From: alan.hannify [REDACTED]
Sent: 24 July 2017 17:45
To: Anita Gardner
Subject: RE: LU/177/17/DOC Compliance with conditions Littlehampton Swimming and Sports Centre

EHO Comments in respect of Condition 10

EHO Comments in respect of Condition 15

ID	Calculated Sound Pressure Level
R1	22
R2	23
R3 Ground Floor	20
R3 First Floor	21
R3 Second Floor	22
R4 Ground Floor	20
R4 First Floor	22
R4 Second Floor	23

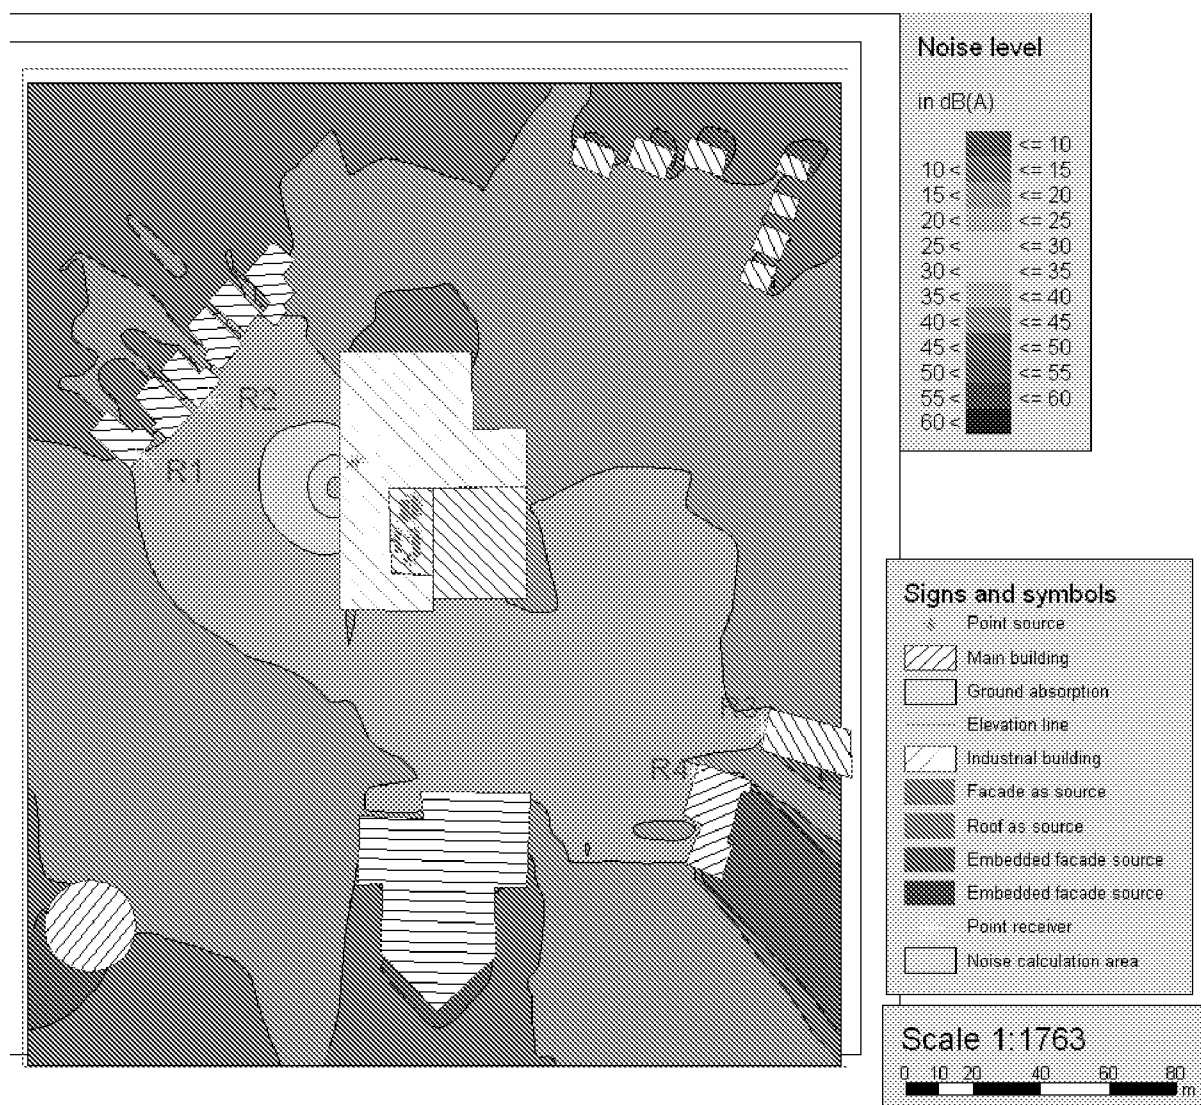
I refer to the acoustic report provided by Pace Consult, dated 31 May 2017. This report provides mitigation measures required to ensure that the plant and equipment installed will provide a suitable acoustic environment and prevent disturbance to residents living close by. However, the mitigation measures referred to give detail of specific acoustic attenuation required across a range of frequencies but lacks evidence of how this will actually be practically achieved on site i.e. there is lack of evidence provided on specific materials or acoustic systems that will be installed to achieve the required attenuation for different pieces of plant and equipment. The report also fails to confirm that the noise levels from all plant and machinery shall not exceed 30dBA between 07.00 -23.00 hours and 28dBA between 23.00 -- 07.00 hours when measured according to BS 4142 at any adjoining or nearby noise sensitive premises.

The above comments were considered by Pace Consult and they advise that their report includes the mitigation measures which should be implemented on-site, in order to reduce the noise emission from the proposed plant at the nearest receptors (section 4). Pace Consult do not provide specific products, this should be provided by the manufacturer or supplier. The manufacturer/supplier should provide the relevant attenuators based on the recommended TL dB.

The Pace Consult report includes the noise impact assessment based on BS4142:2014 which is included in page 17. The assessment is based on the worst case scenario which is all plant items working constantly during the lowest measured background levels, which is 28 dBA (measured during night time). Please refer to page 2 of the report.

The assessment table shows that the noise from plant is equal to or less than the lowest measured background, therefore this is an indication that the specific sound levels have a low impact at nearest noise sensitive receptors based on BS4142:2014 methodology.

The first page of the Pace Consult report clearly specified the period and plant condition of the noise assessment: The sound pressure levels from the Littlehampton Leisure Centre have been assessed during night time period with all plant items operating continuously.
